Your Ref:DC/22/01865
Our Ref: SCC/CON/1601/22
Date: 25 April 2022
Highways Enquiries to: Highways.DevelopmentControl@suffolk.gov.uk

TOWN AND COUNTRY PLANNING ACT 1990 CONSULTATION RETURN: DC/22/01865PROPOSAL:
Full Planning Application - Construction of new vehicular access.

LOCATION: Glebe House, The Street, Stowlangtoft, Bury St Edmunds Suffolk IP31 3JR

TITLE: OUTLINE PRIVATE DRIVEWAY ACCESS

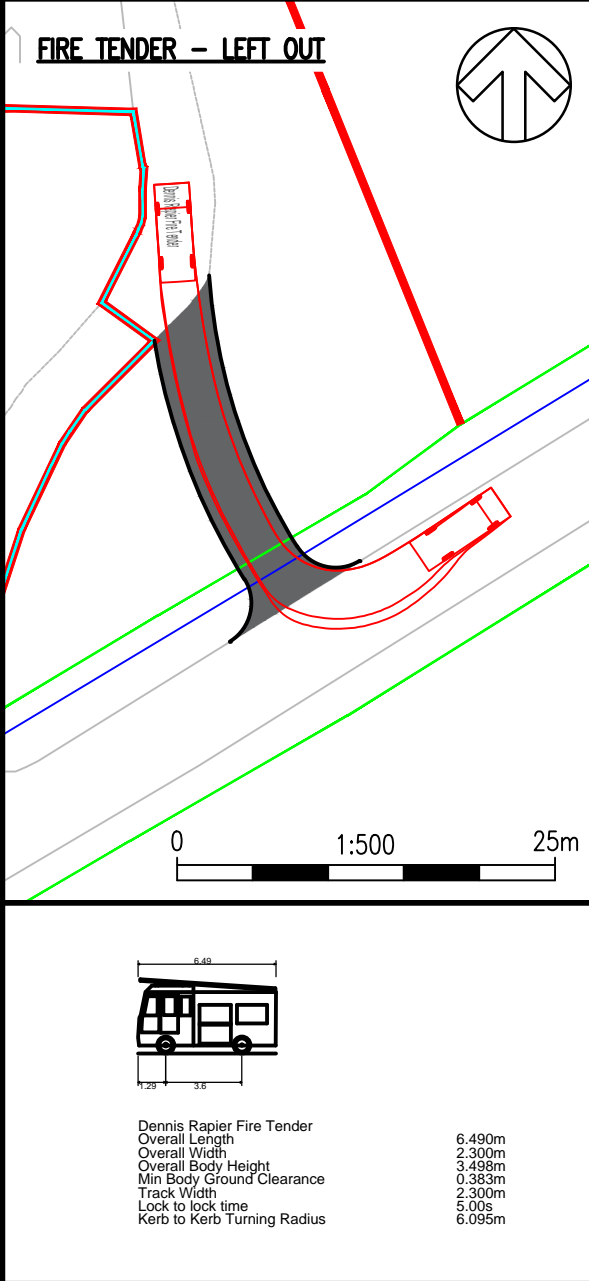
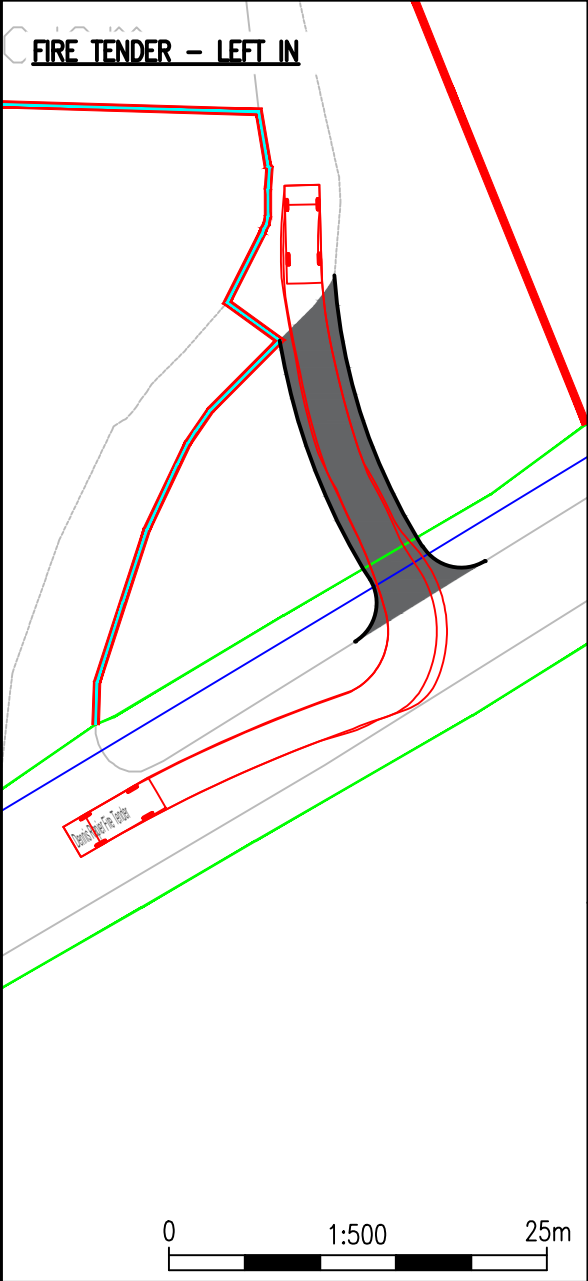
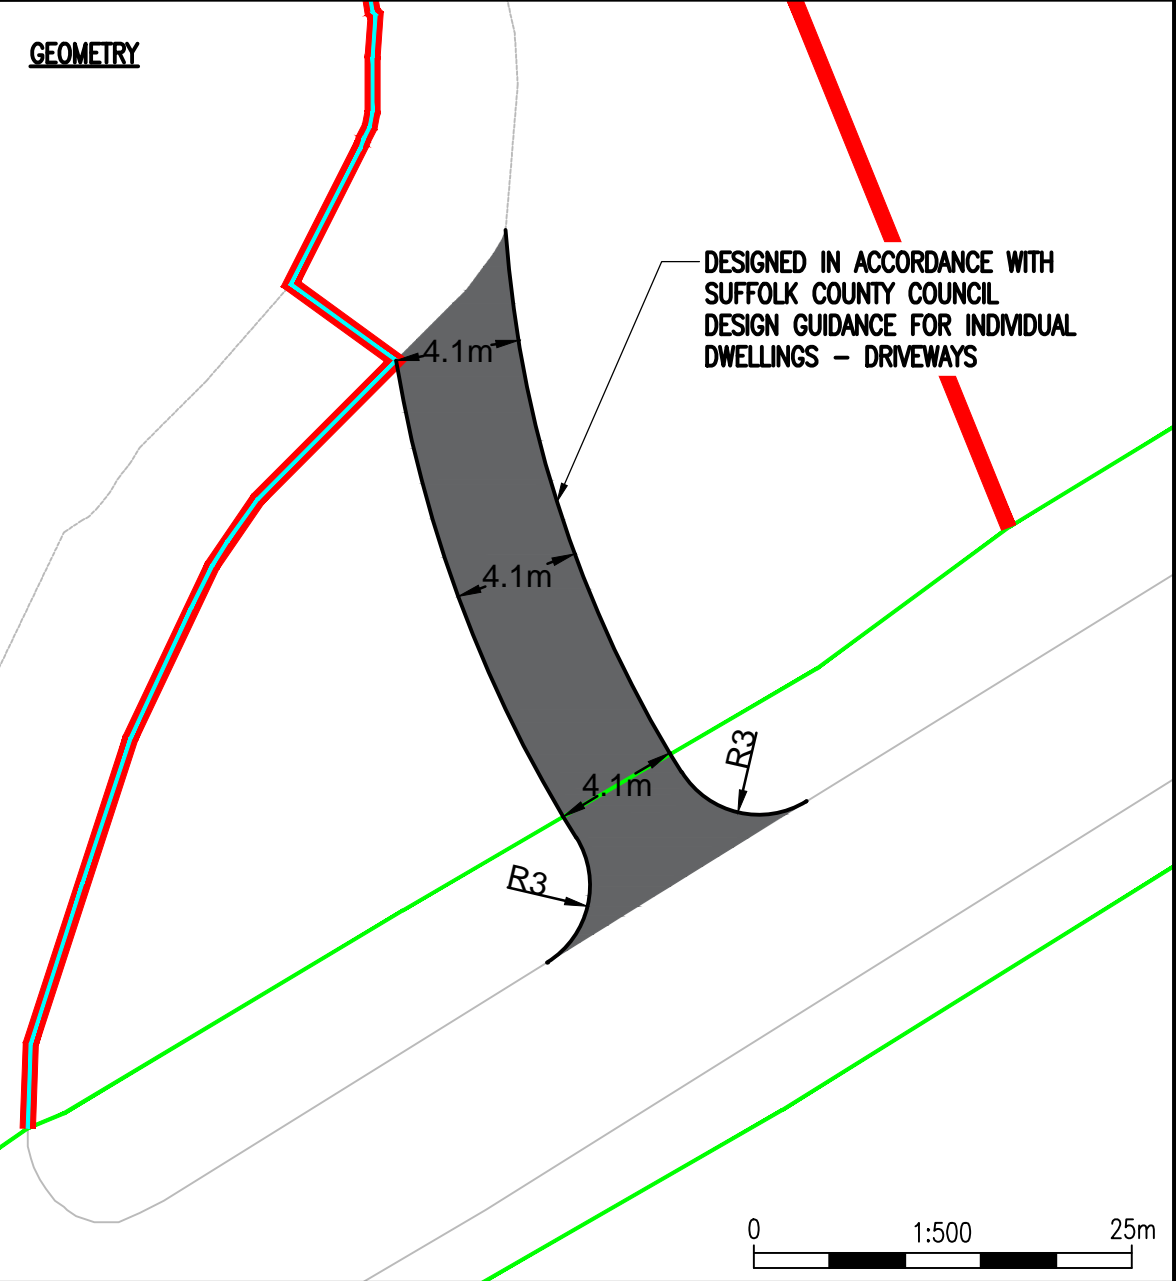
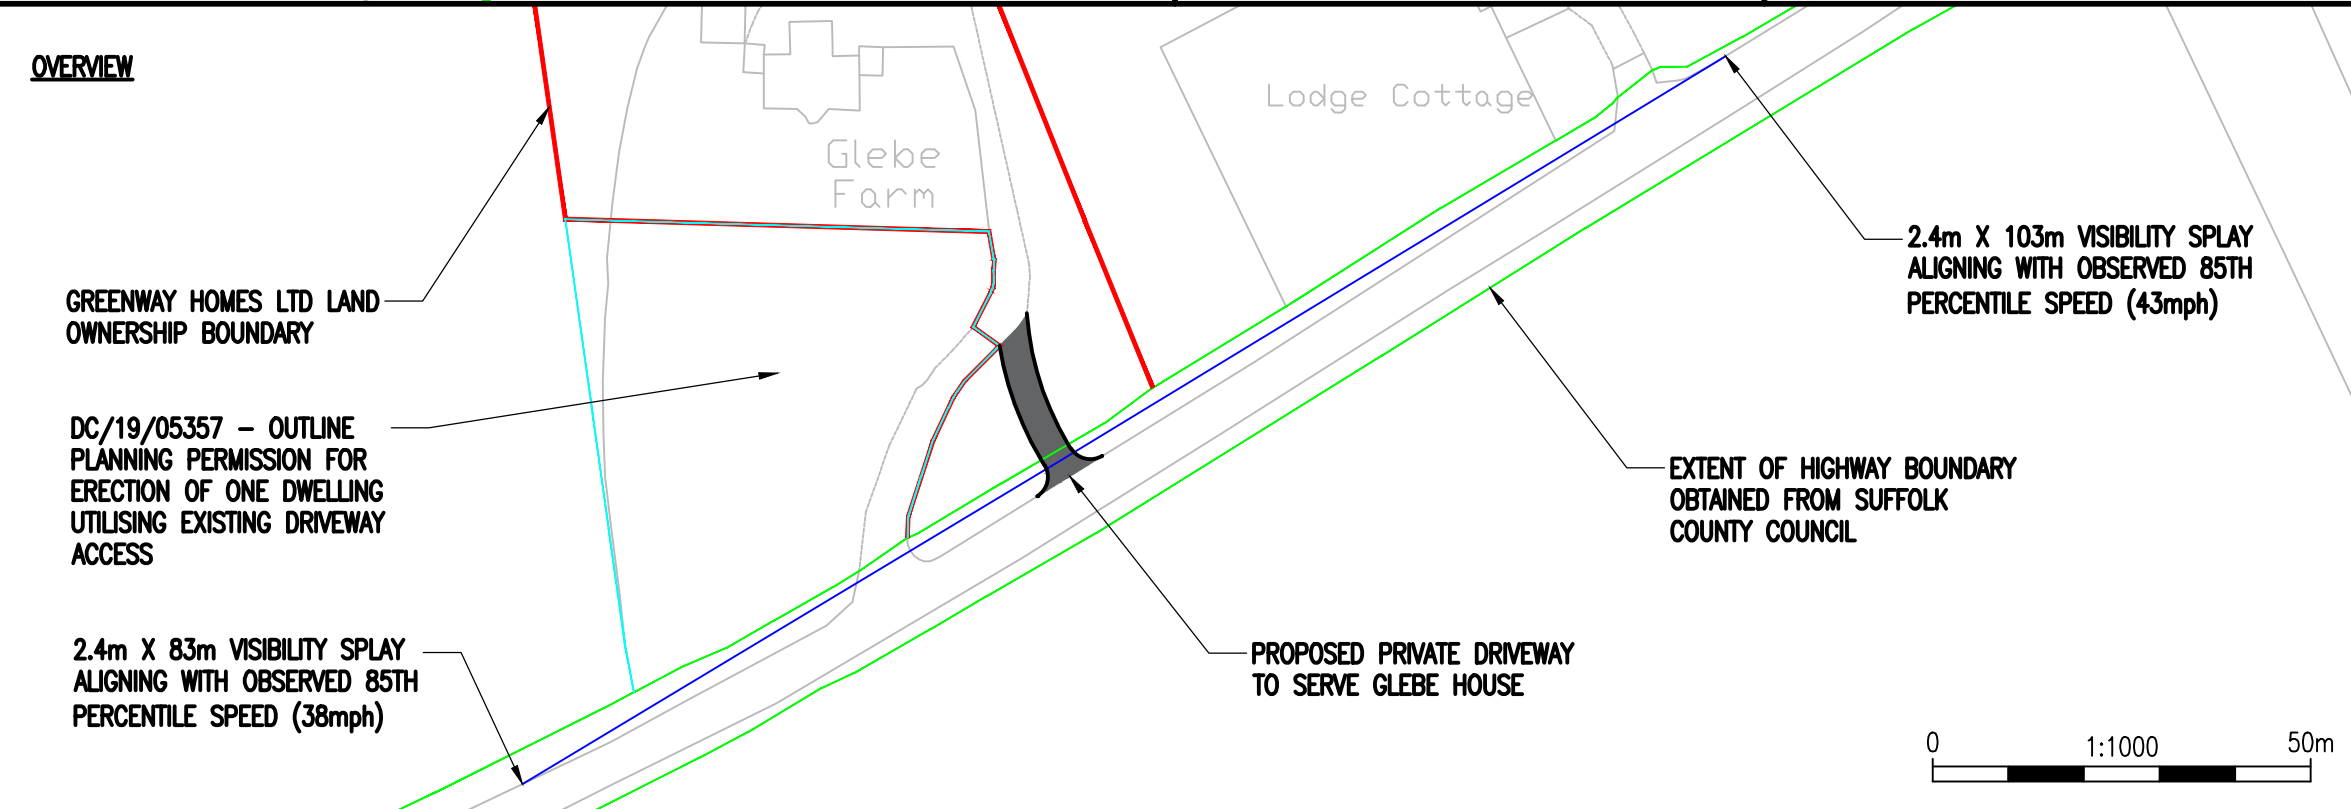
Condition: Before the access is first used visibility splays shall be provided as shown on Drawing No. GHST-WSP-XX-00-TP-DR-0001 REV A with an X dimension of 2.4 metres and a Y dimension of 103 metres in the North east and 83 metres in the South west. [tangential to the nearside edge of the carriageway] and thereafter retained in the specified form. Notwithstanding the provisions of Part 2 Class A of the Town & Country Planning (General Permitted Development) Order 2015 (or any Order revoking and re-enacting that Order with or without modification) no obstruction to visibility shall be erected, constructed, planted or permitted to grow over 0.6 metres high within the areas of the visibility splays.
